Subject: RE: Attached letter from Kirklees Council regarding application number 2025/91370 at location Land at, Gynn Lane, Honley, Holmfirth, HD9 6LF

Further to a review of the additional/amended information provided, I would like to reaffirm the following conditions:

CULVERT LOCATION PLAN SCALE 1:200

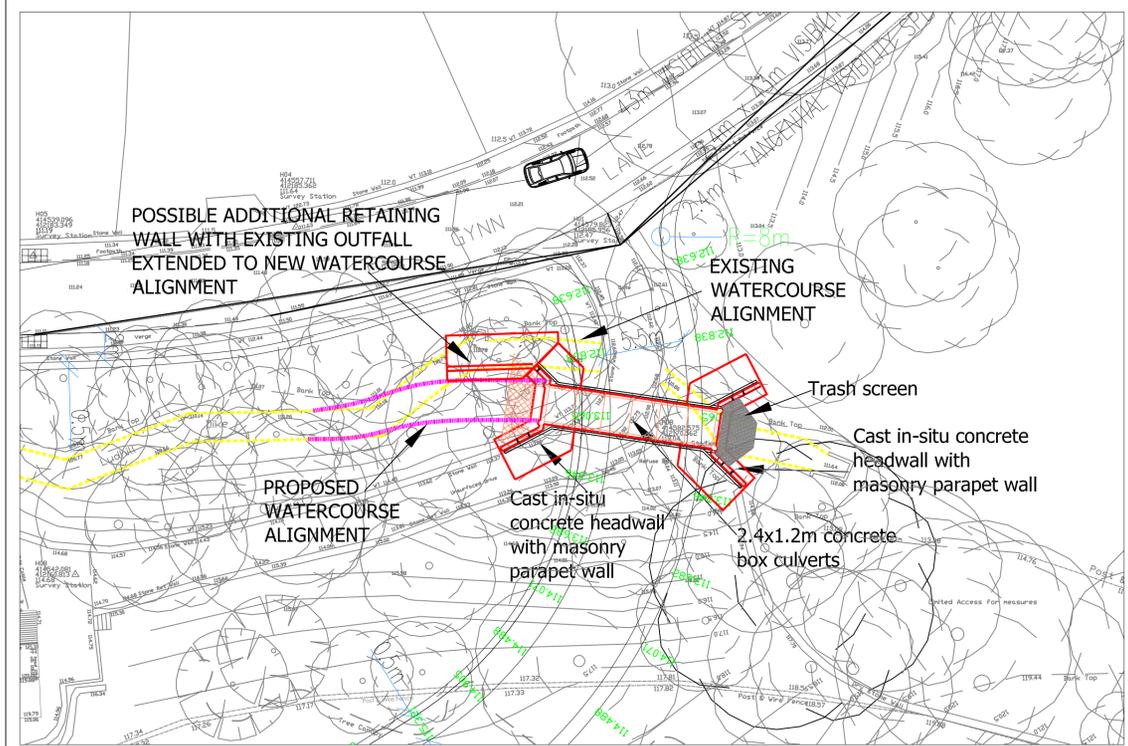
- 2) Before the development commences, the alignment and the design of proposed culvert under the new highway shall be submitted (via submission of an AIP) and approved by the Highway Authority in writing. The approved scheme shall be implemented prior to the commencement of the proposed development and thereafter retained during the life of the development.
